Development Control
Ribble Valley Borough Council

Re: Planning Application 18/0303

Address: CROFTLANDS BROAD MEADOW PR3 2GH CHIPPING

Description: ERECTION OF FOUR NEW DWELLINGS

SITE PLAN_AS PROPOSED

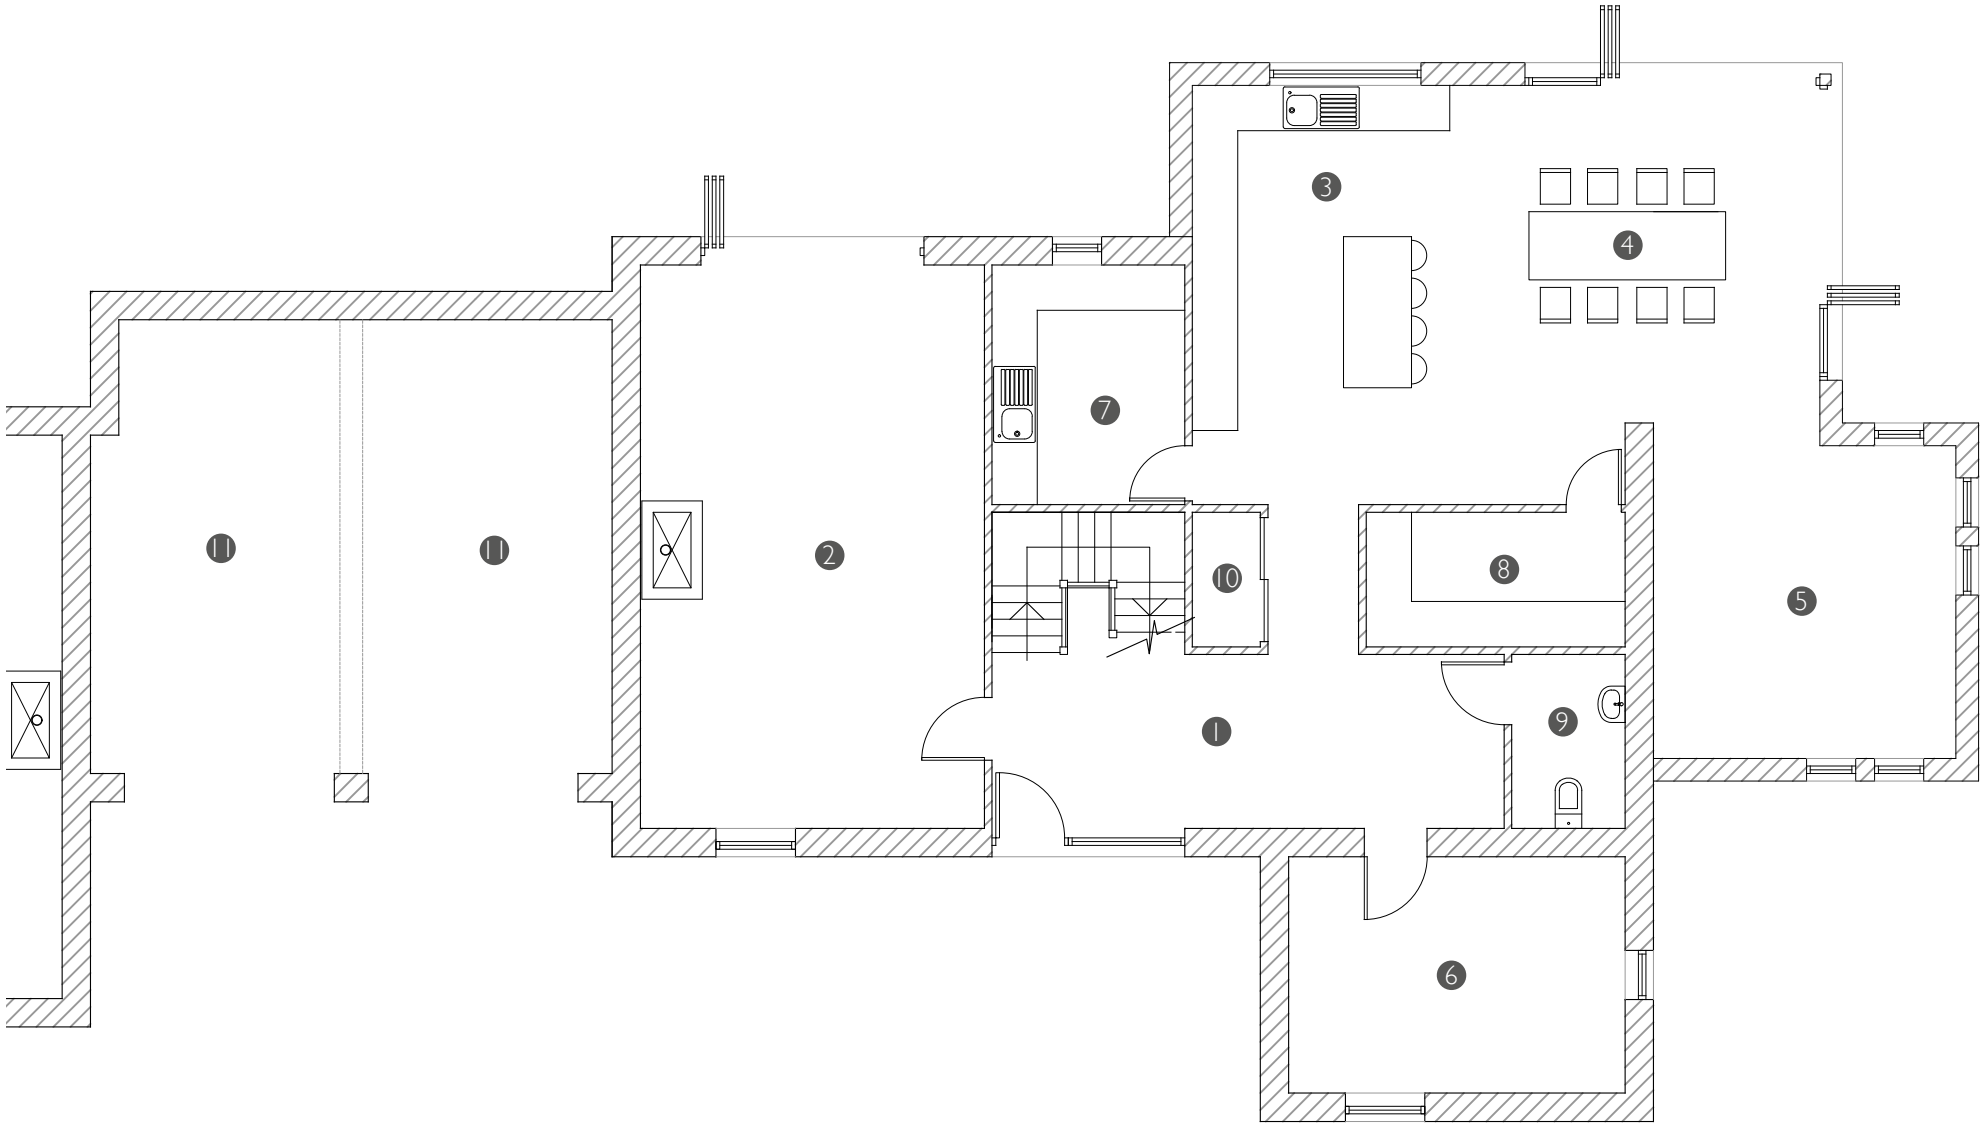
There are concerns regarding the site layout, a suitable turning head is required to accommodate larger vehicles such as a Fire Engine and refuse collection vehicle. Whilst the dimensions of Fire Engine are not known Ribble Valley refuse collection vehicles are known to have 3 axle, be 9.25m in length and 2.35m wide. In relation to refuse collection the bin storage point is unacceptable, the distance from a number of the plots to the bin store is too great according to the Department of Transport's document Manual for Streets, this states that householders are not expected to carry waste for more than 30m to the bin store and that collection vehicles should not have to reverse more than 25m to the collection point.

Other concerns relate to the off street parking for the development and the existing dwelling. It is noted that the existing garage door will no longer be accessible when the new hedge line is planted, the existing dwelling is believed to be a 3 bedroomed property and as such under Lancashire's Structure Plan this should have 2 parking spaces. Similarly, under the parking strategy it is expected that the proposed dwellings should have 3 parking spaces each, these should be at least 5.5m long by 2.4m wide. In order for a garage space to be included, the internal measurements of each garage space should be 6m by 3m to allow for car doors to be opened and still allow room for the storage of general gardening equipment and cycles in order to support sustainable transport solutions. In this instance if car ports are used, additional covered and secure storage would be expected for cycles and other such household items.
